**Re: PA22-040 – 87th & 40th PRD – Technical Review 1
4218 / 4112 / 4018 / 3922 / NNA 87th Ave NE
CORE Project No. 21036**

The purpose of this letter is to provide a response to the review comments for PA22-040 – 87th & 40th PRD – Technical Review 1 - 4218 / 4112 / 4018 / 3922 / NNA 87th Ave NE dated October 21, 2022. We have addressed each comment and revised the plan/documentation accordingly. This letter contains the review comments immediately followed by our response to each in bold lettering.

12/15/2023 3:58 PM A:\2021\21036\ENGINEERING\PRELIMINARY\SHEETS\21036_C4.01.DWG

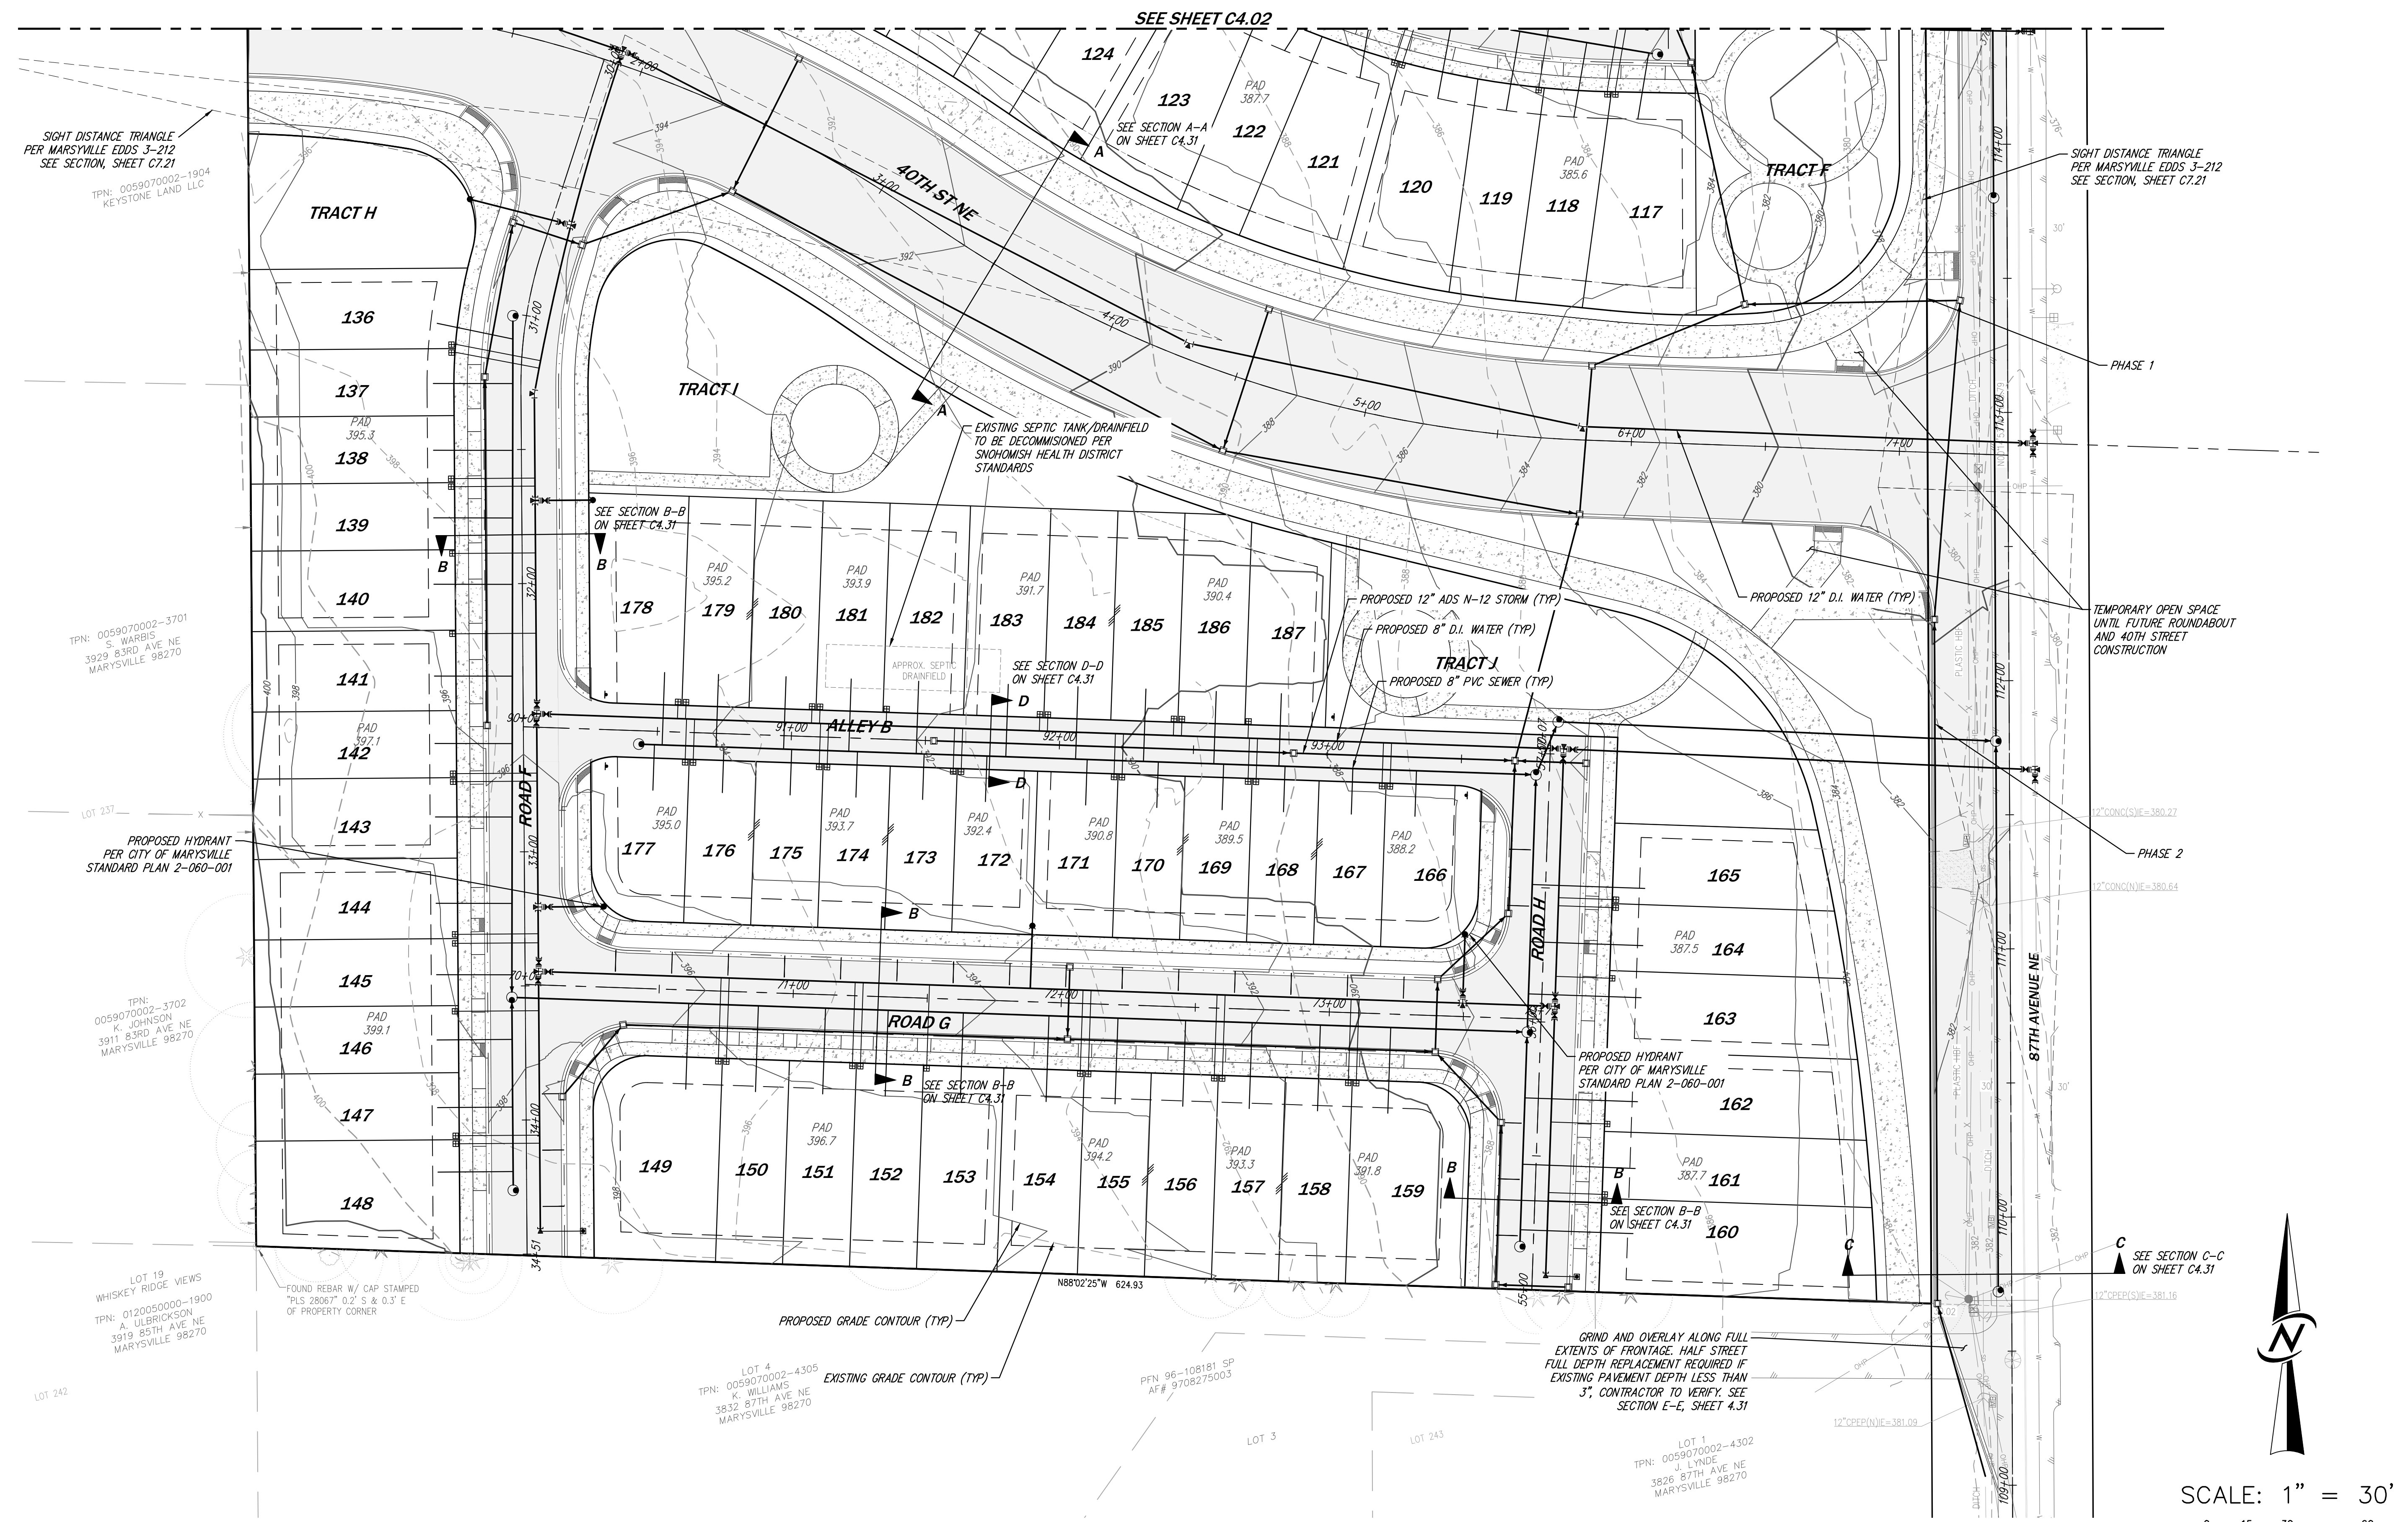
2. The provided plans (civil, landscaping, and site) appear to include multiple retaining walls throughout the proposed development. Provide call out details for said walls and/or include wall symbols in legend.

- On Sheets C4.01 – C4.02 of the civil plans, not all of the open space tracts are labeled. For consistency, please ensure that all tracts are labeled.

Response: Detail added to sheet C4.01, callouts for 4-ft max height & proposed top & toe of wall are included.

Response: All open space tracts are now labeled.

SHEET	OF
C4.33	30
PROJECT NUMBER	21036

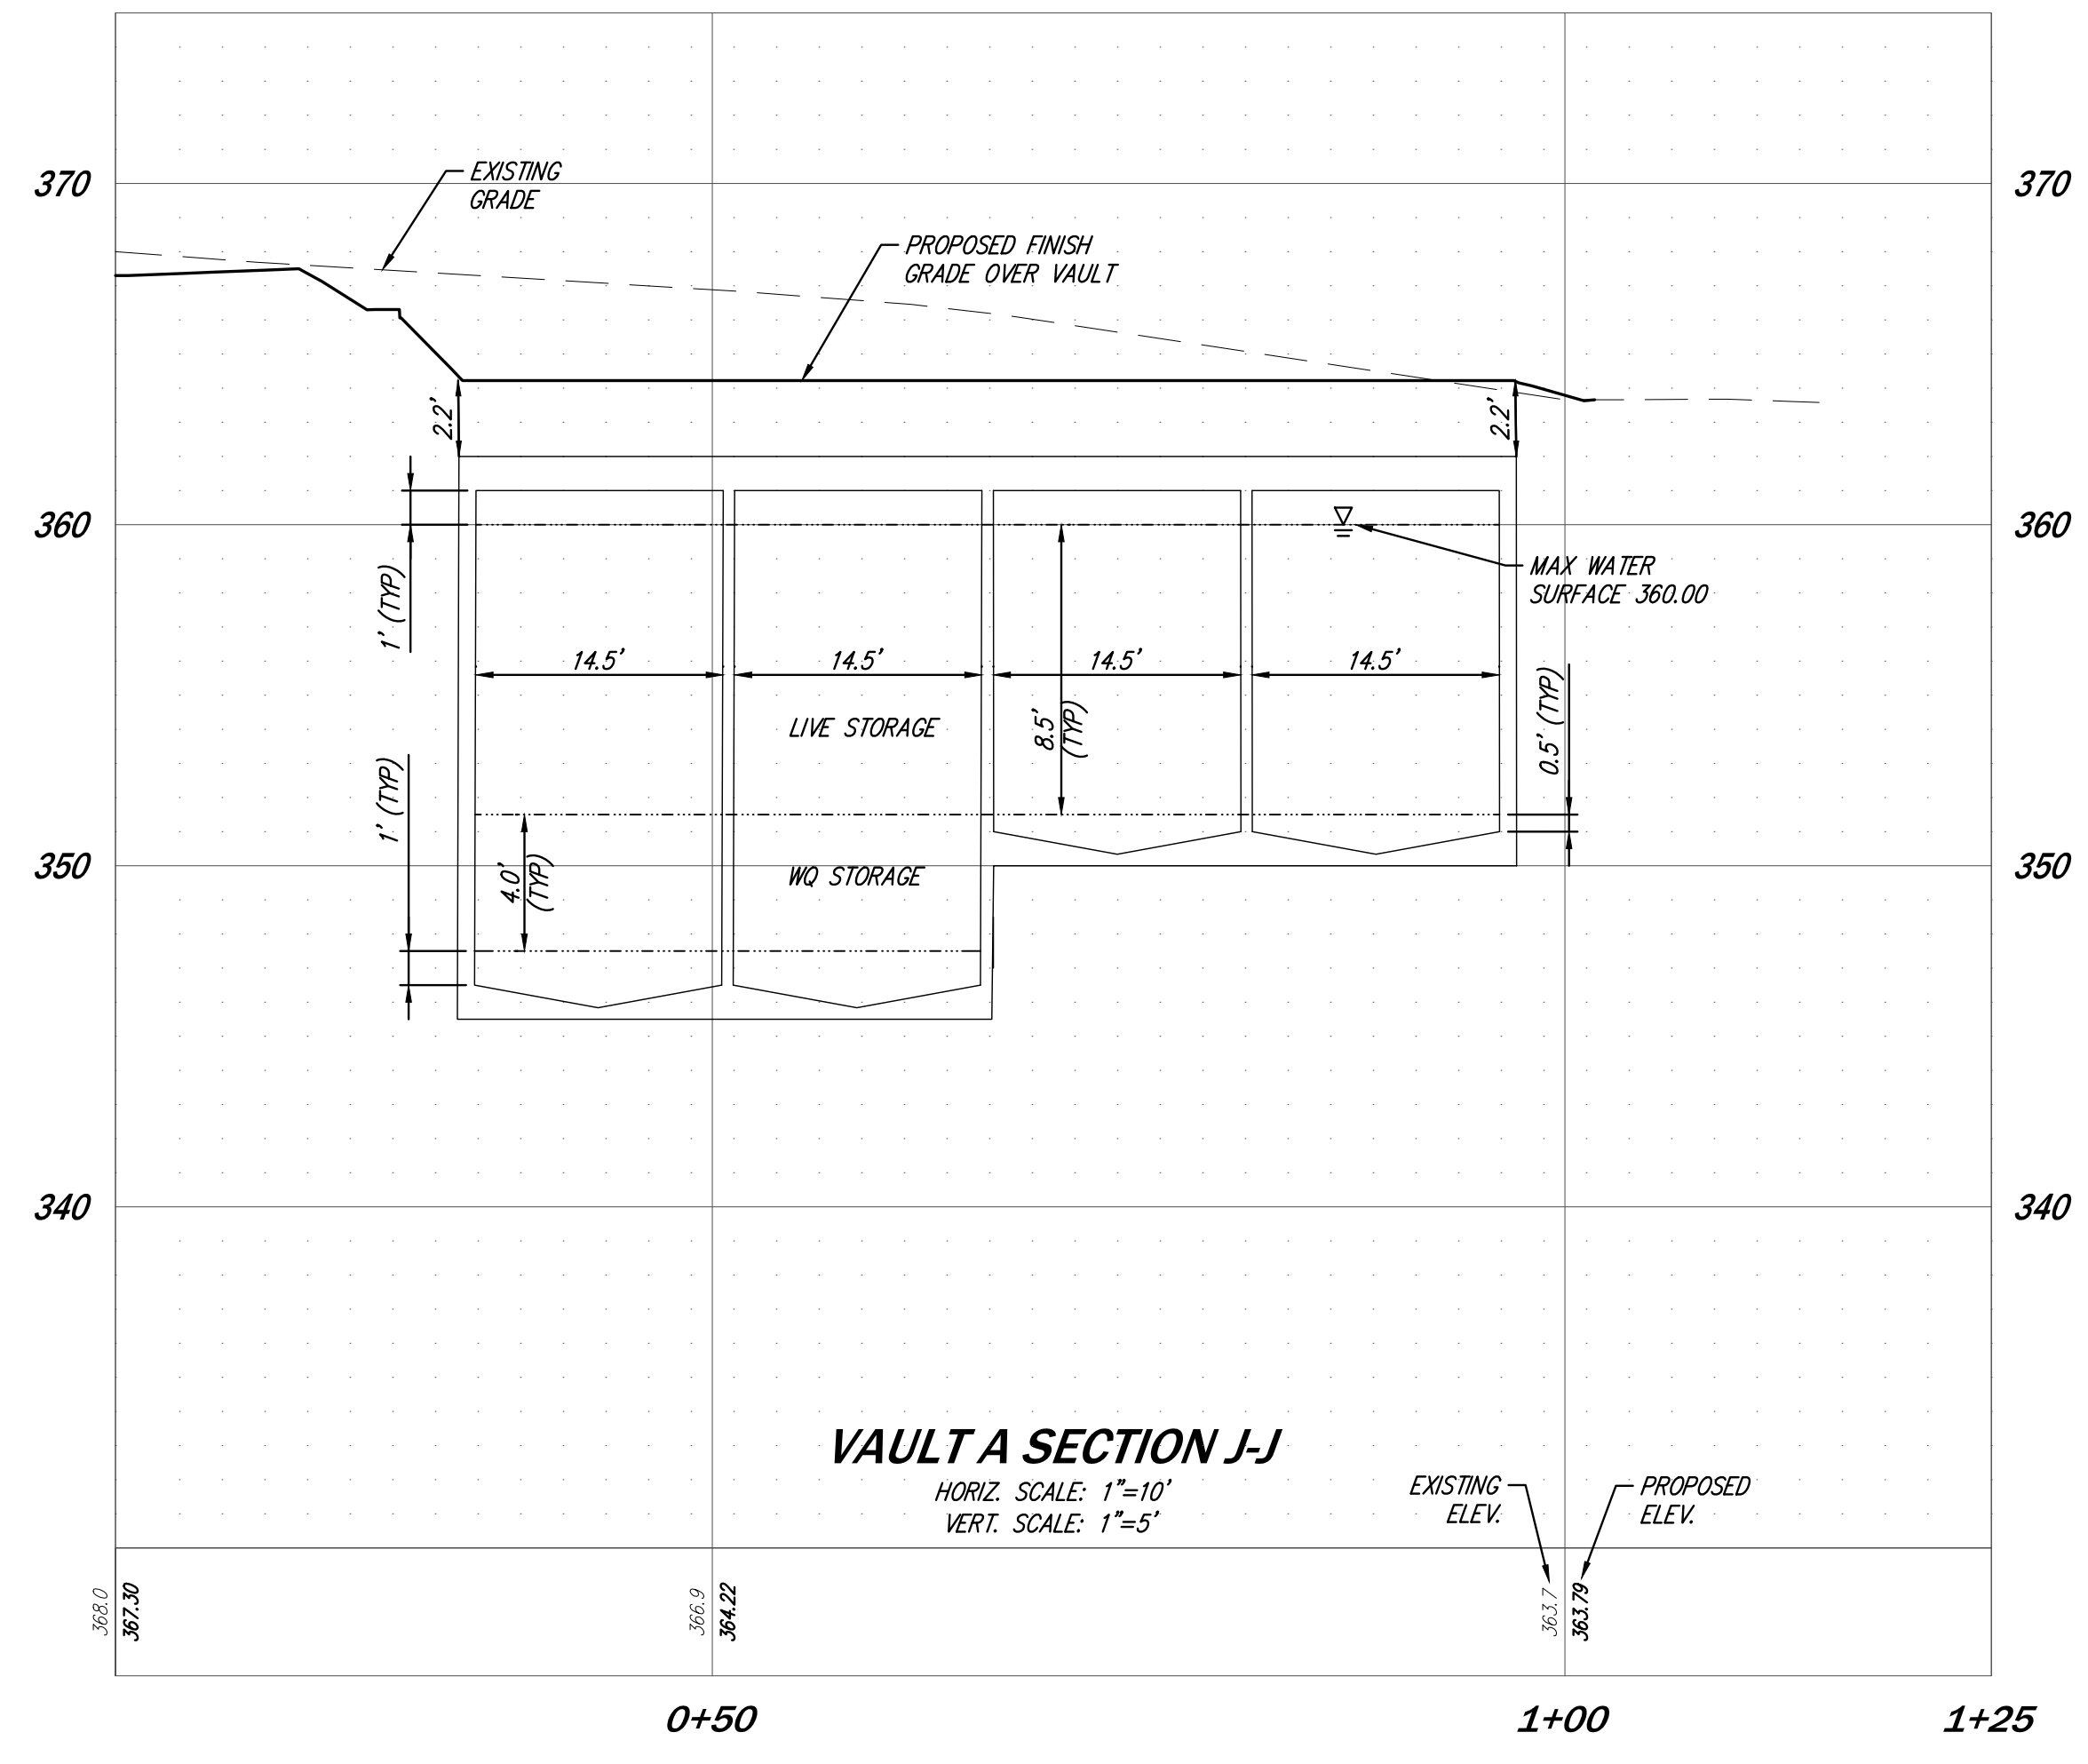
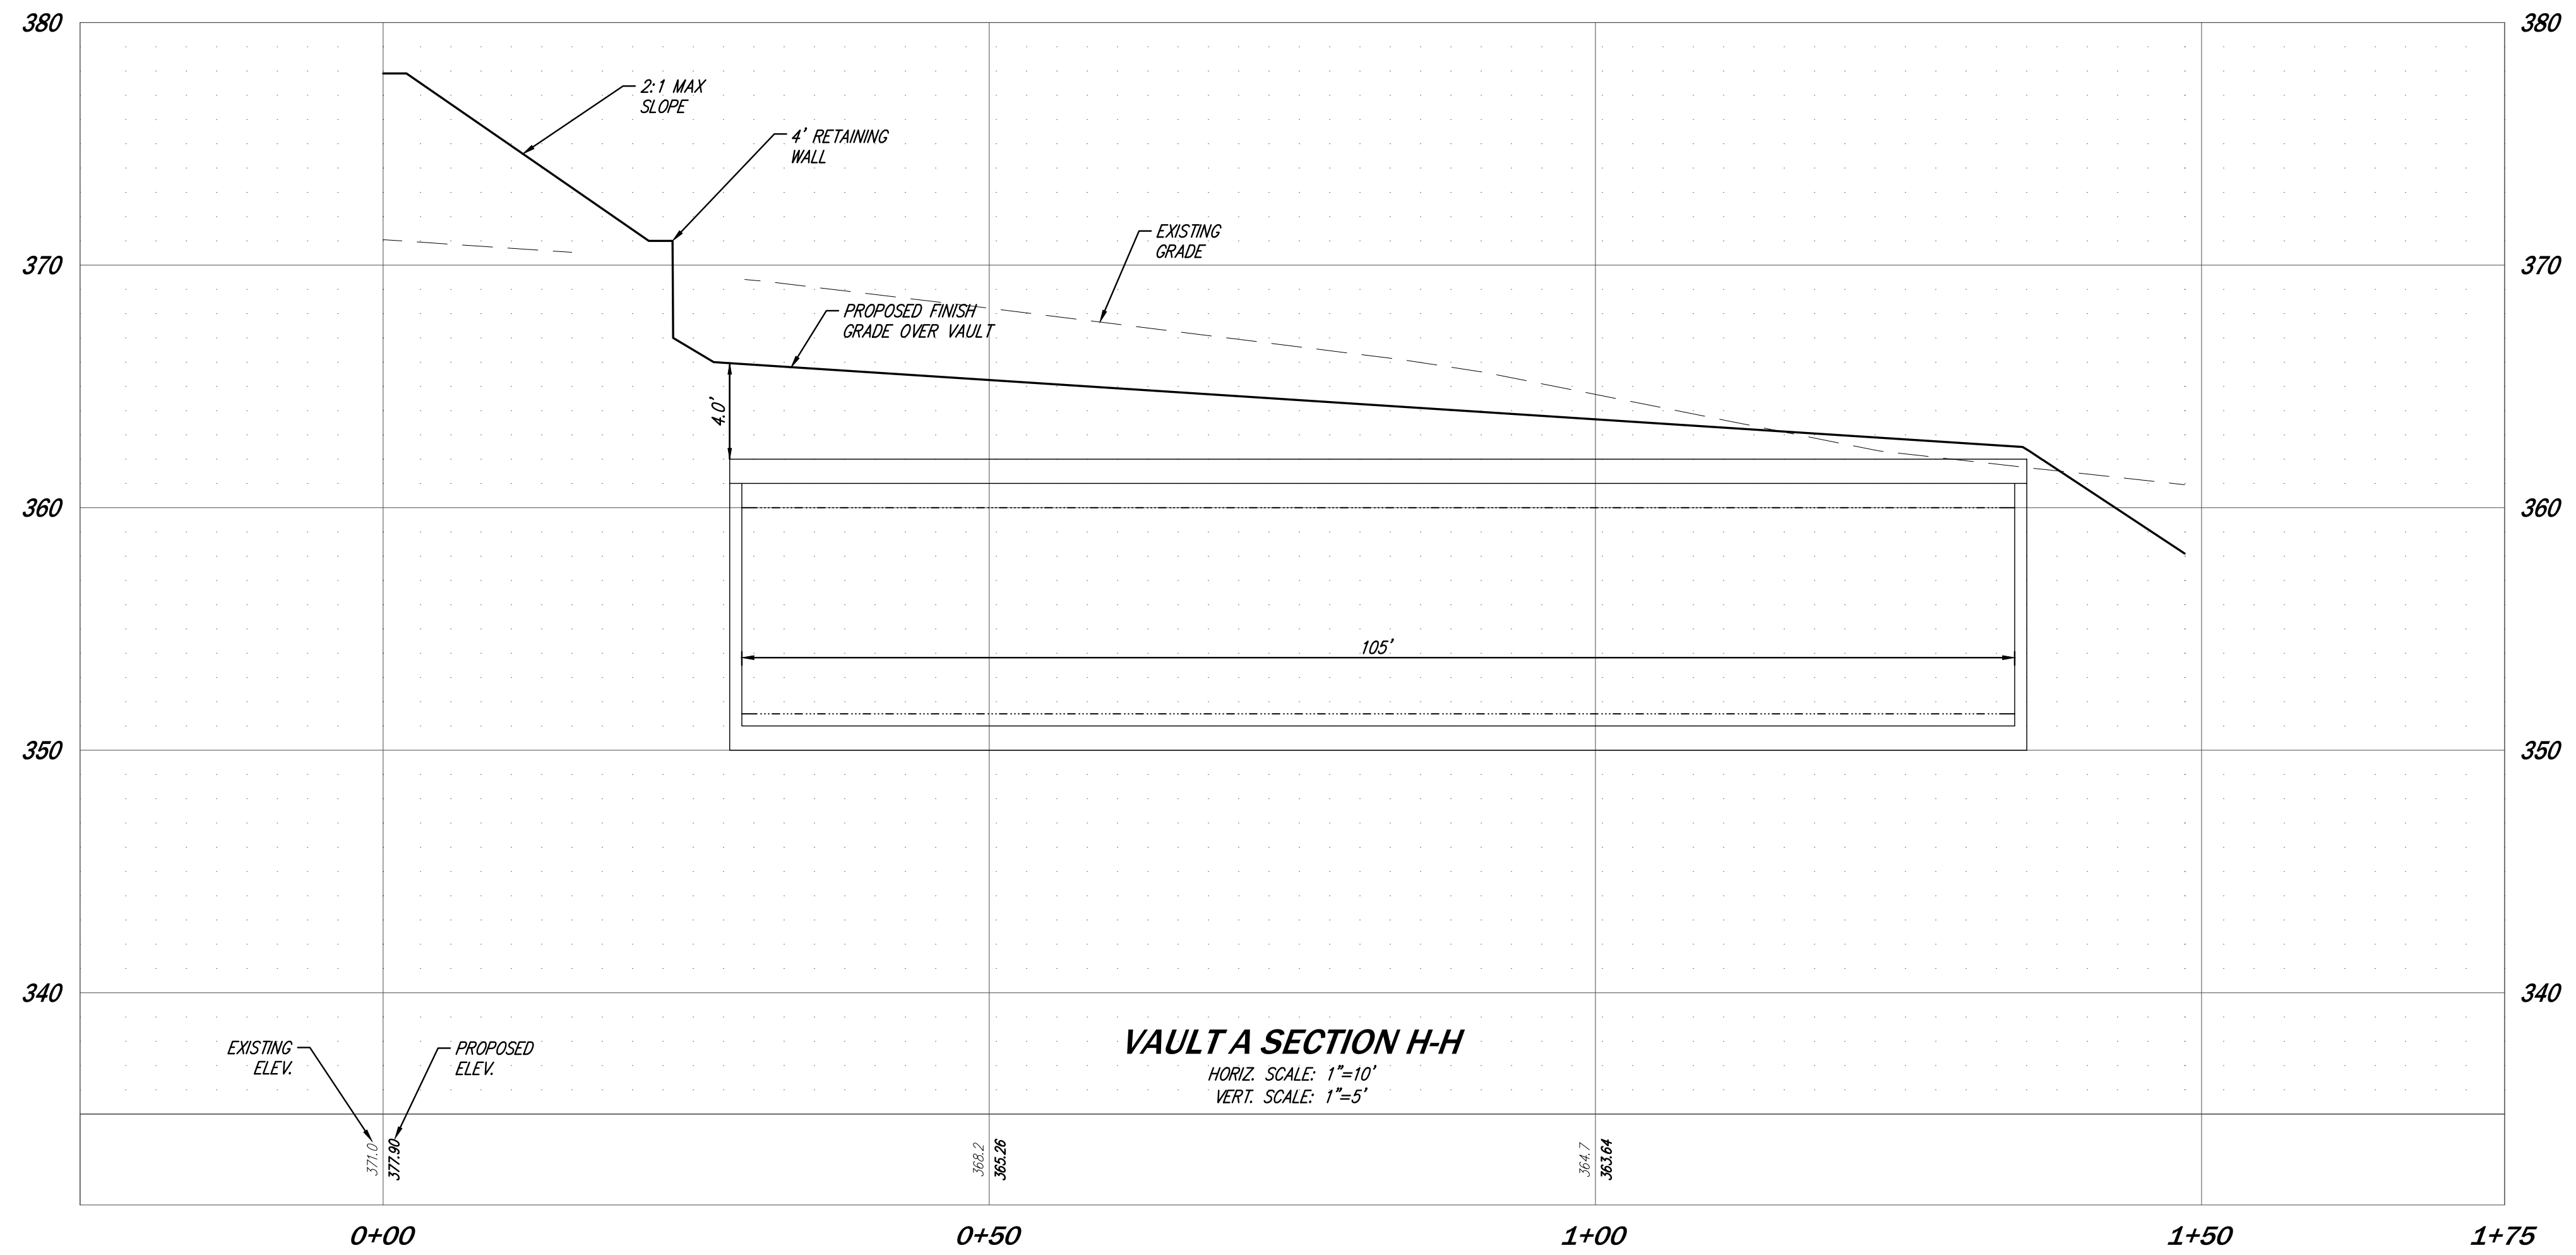
- a. All new roads shall be constructed to SP 3-202-002 with a 50' ROW and 28' of roadway.

Response: All roads are now 50' wide. Per our email correspondence with Ken McIntyre on January 31, 2023, roads are proposed to be constructed per PRD Access Street with Street Parking SP-218-001. However, in lieu of vertical curb rolled curb is proposed. Please refer to Section B-B on Sheet C4.31 for the proposed cross section.
